Please upload the below to the above application: Conservation Officer comments

AL/70/20/PL

West Barn Old Dairy Lane Norton PO20 3AF

Residential Mews consisting of 6 No dwellings. This application may affect the Norton Lane, Norton Conservation Area, may affect the setting of a listed building.

PROPOSED FULL MEWS SOUTH ELEVATION

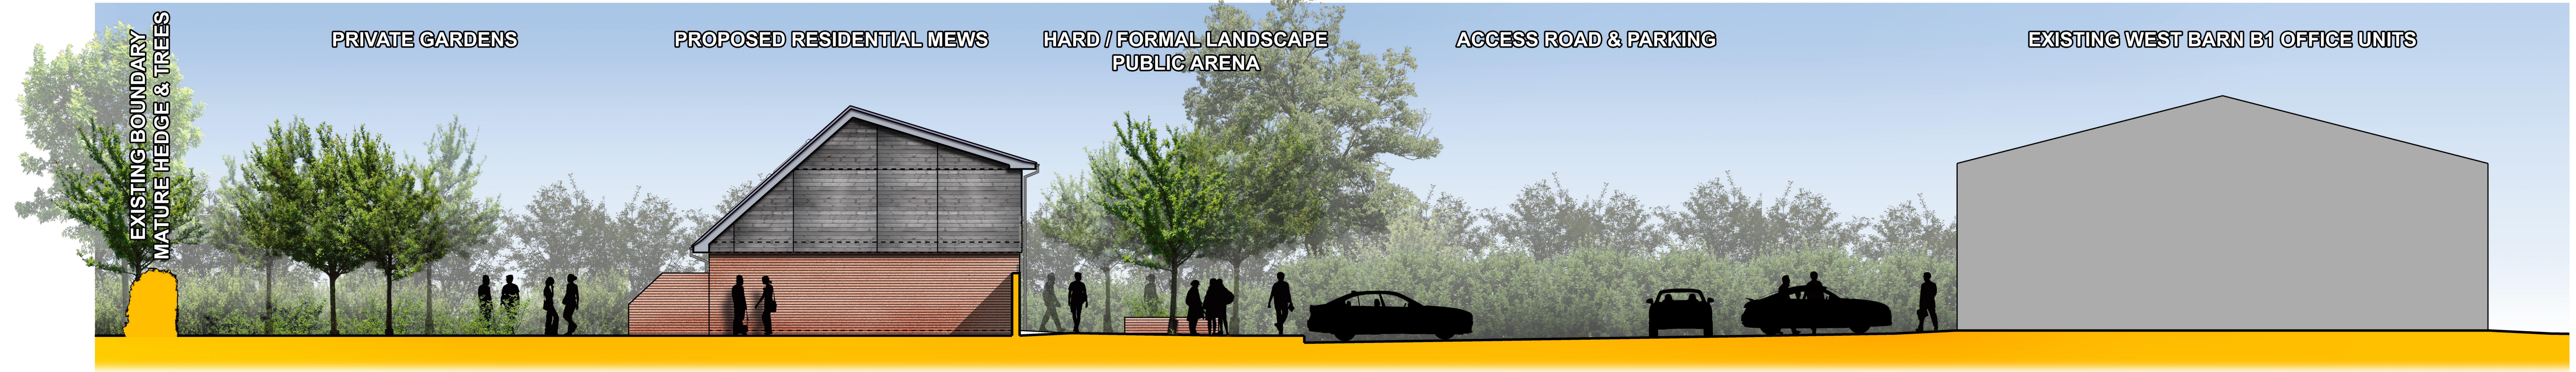
The proposed units would reflect the layout and design of West Barn, that is to say a similar large building in modern style, with a simple glazing pattern. It would be divided from the existing building by a landscaped courtyard that would provide parking for the proposed units. It would also include an area of hard landscaping to the front of the new terrace with what looks like planters. If constructed, this would almost create an enclave of modern development on the edge of the village/conservation area. This would be in stark contrast from the traditional appearance of the aforementioned former agricultural buildings as well as the buildings located along Norton Lane within the conservation area.

Whilst this approach is understood i.e. reflect the context of the application site, it is also now questioned why the one modern building in the local area has been identified as the precedent for the site when there are plenty of other buildings more appropriate to use as a guide. It is therefore considered that the proposal would be out of character with the more rural, traditional hamlet.

The NPPF states that opportunities for new development within the setting of heritage assets should enhance or better reveal their significance. Therefore, development in this location could take a more traditional, agricultural form/appearance, appearing more as converted traditional agricultural buildings as opposed to a large converted modern agricultural/office structure. Such a development would be similar to the neighbouring converted agricultural buildings and would have a more positive impact upon the conservation area.
